FAREHAM

BOROUGH COUNCIL

**Fareham Borough Council - Relevant Representation
Hampshire Water Transfer and Water Recycling Plant Development Consent Order
Application by Southern Water Services Limited**

Figure 8.14
 Bat Direct / Indirect Impact Zones
 Sheet 5 of 13

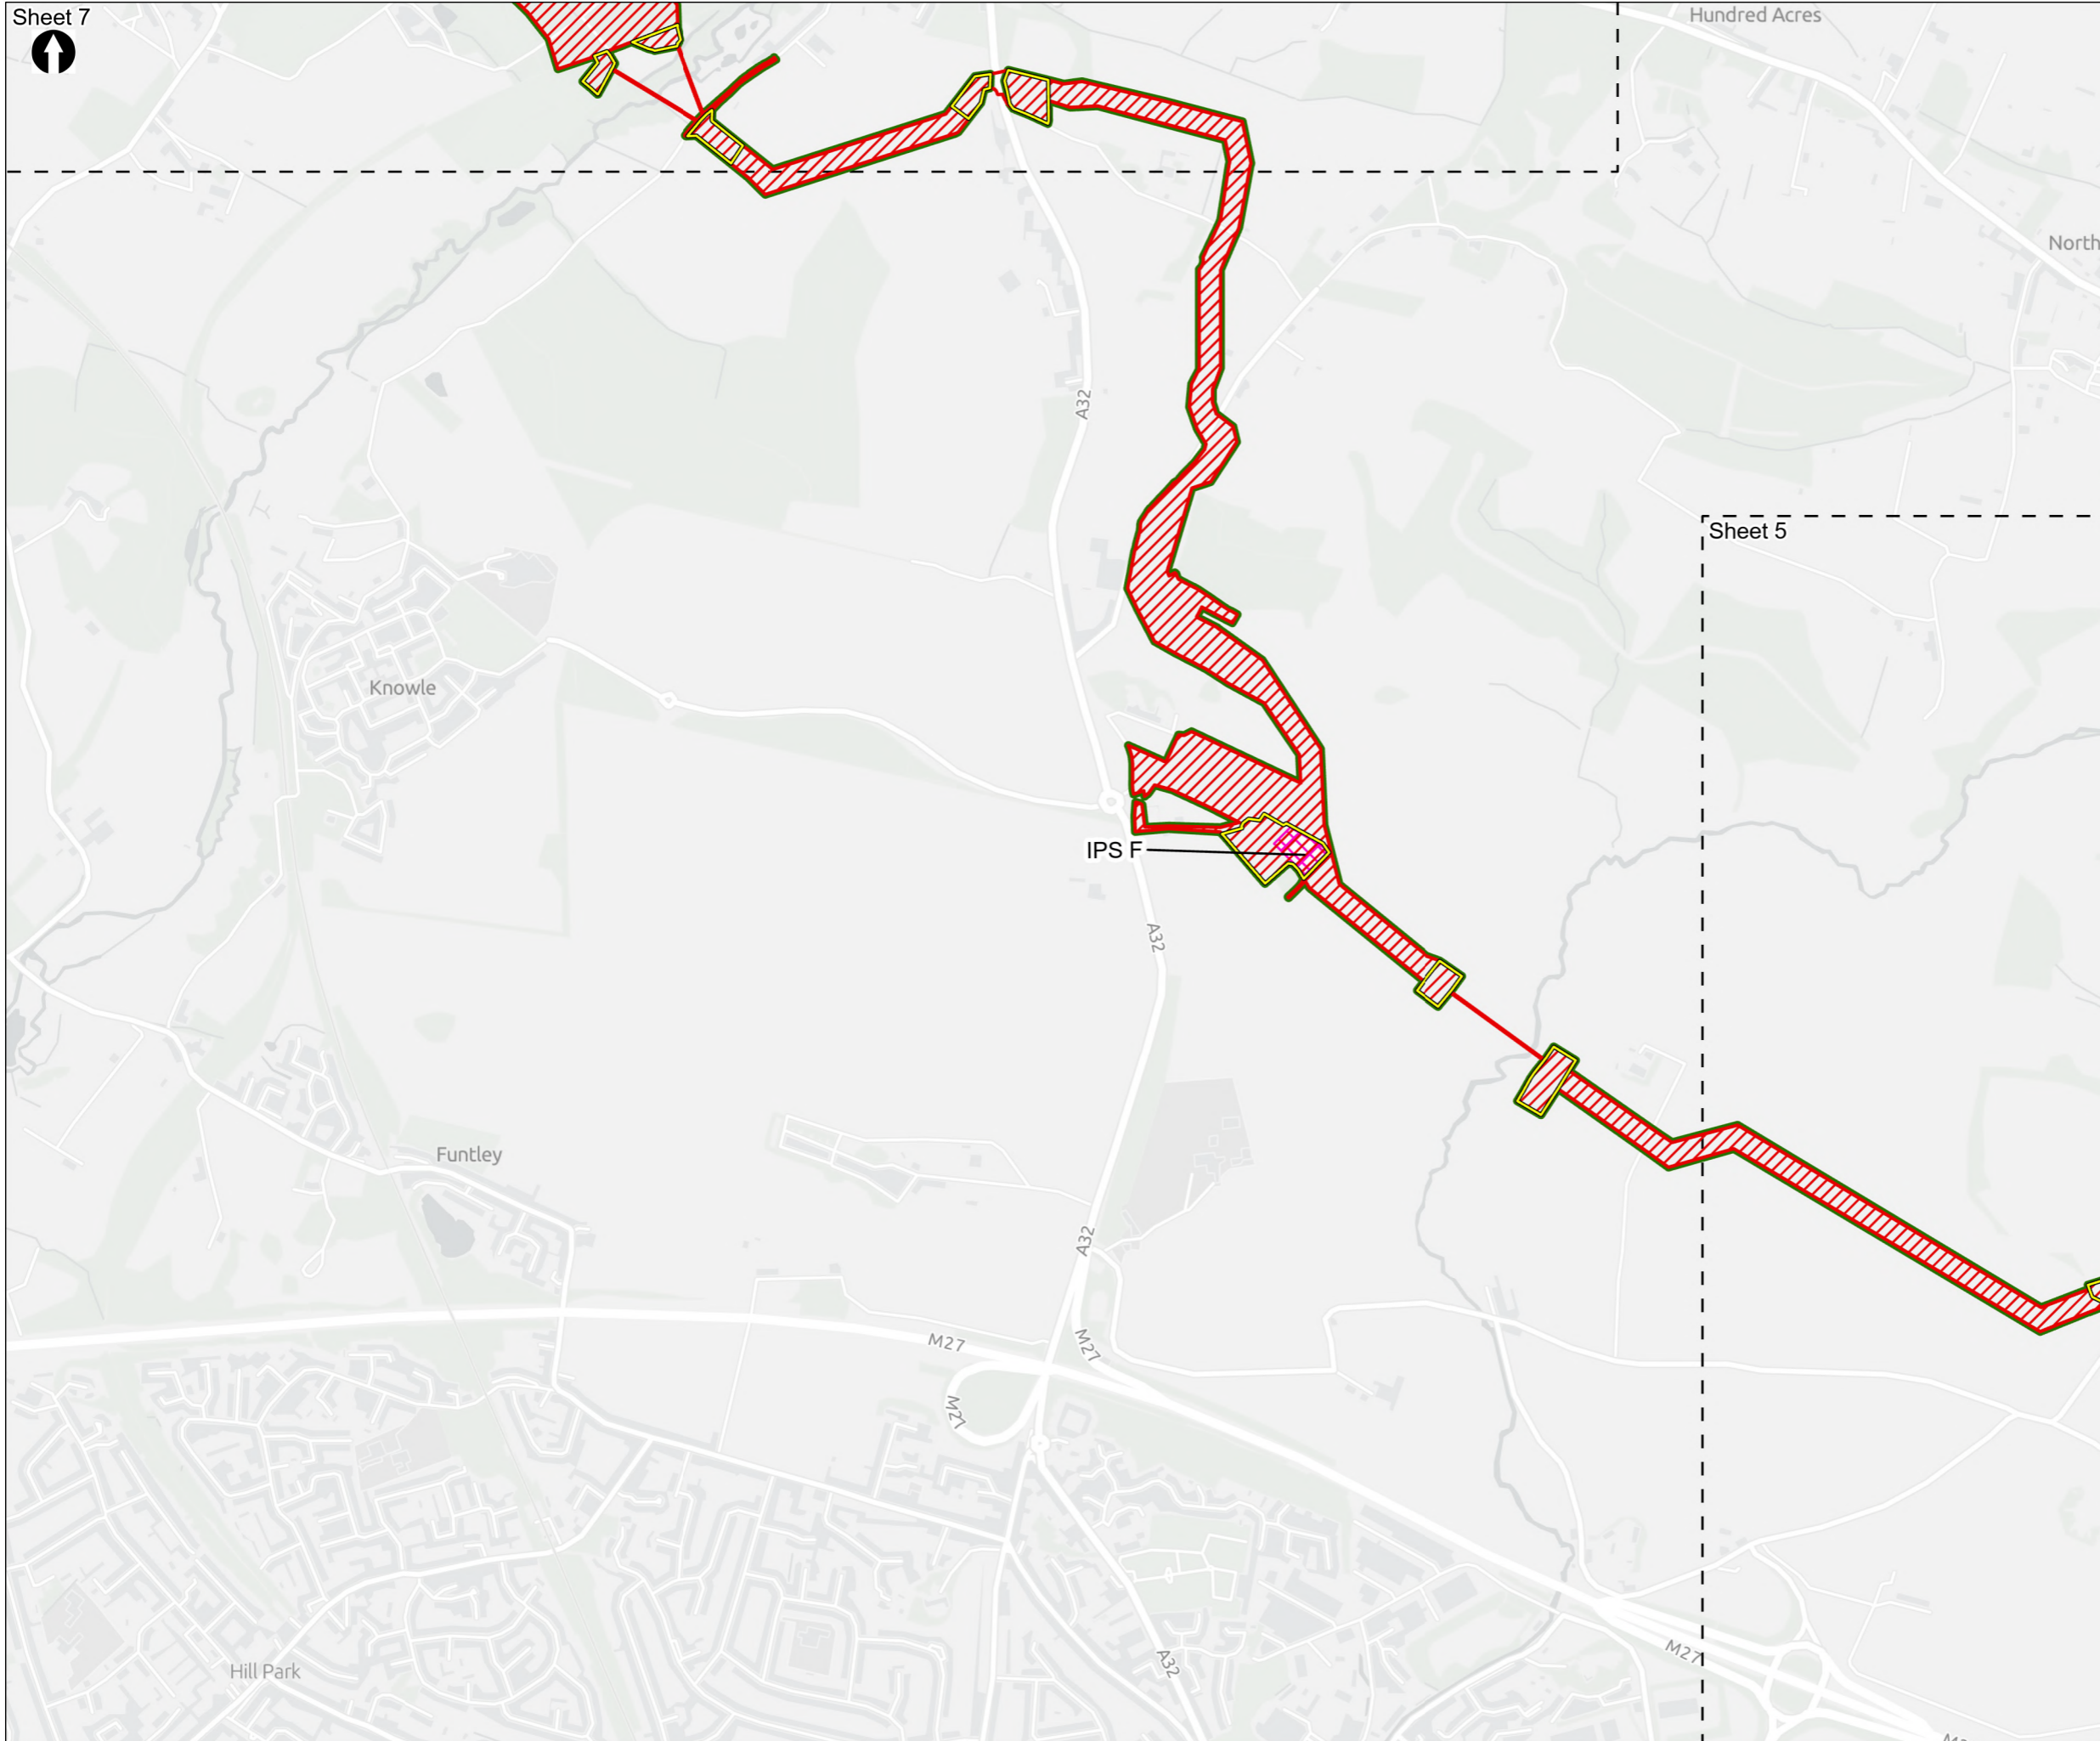
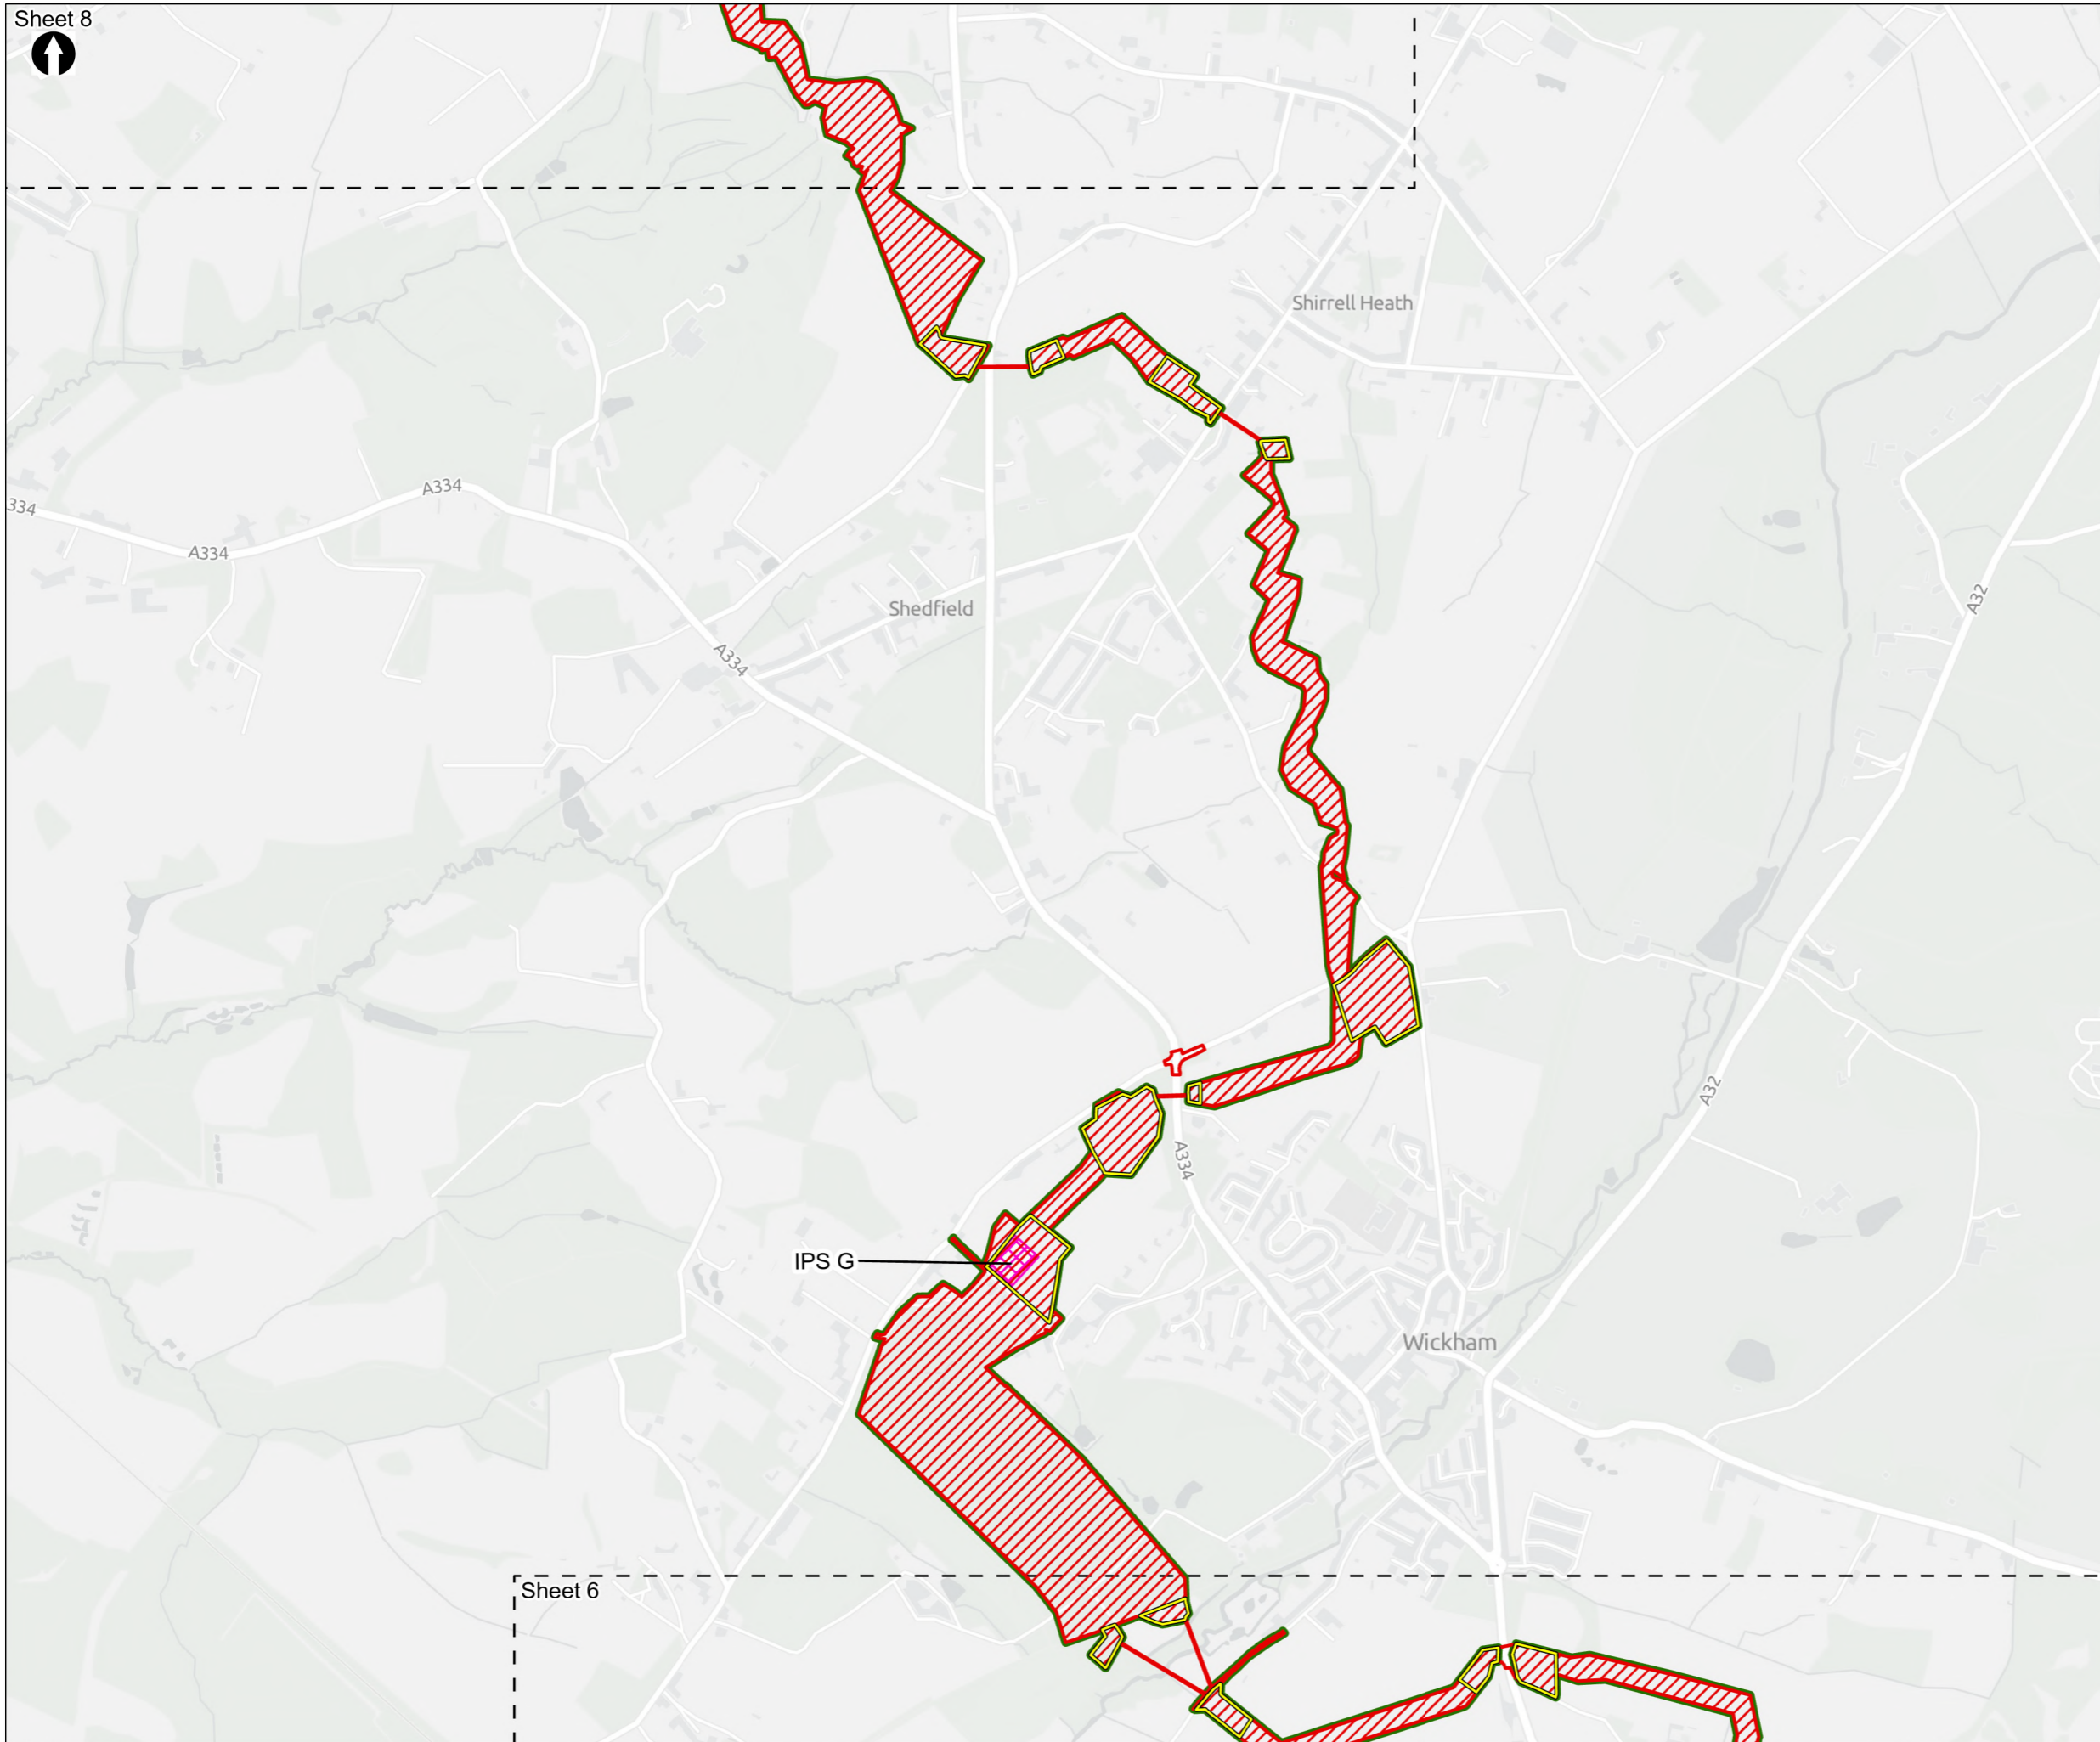
Whilst there will be a 15m buffer between Carpenters Copse Ancient Woodland/SINC and the works, there will be medium-term severance of the woodland/hedgerow network connected to this Ancient Woodland in areas shown below in yellow. Therefore, FBC is not clear why the modelling and survey work (statics and nighttime bat walkovers) did not cover this area, as a sampling location and key connective location, for the presence of bats, particularly Annex II bat *Barbastelle*. Instead, a static was placed at the crossing with the River Wallington, where the impact is limited due to the trenchless nature of the crossing. Given the large number of Ancient Woodlands located to the east, west and north of Carpenters Copse, it is not considered that sufficient survey work has been carried out to understand the baseline and enable impact assessment/proportionate mitigation in the areas to be affected as a result of severance of commuting routes for bat populations.
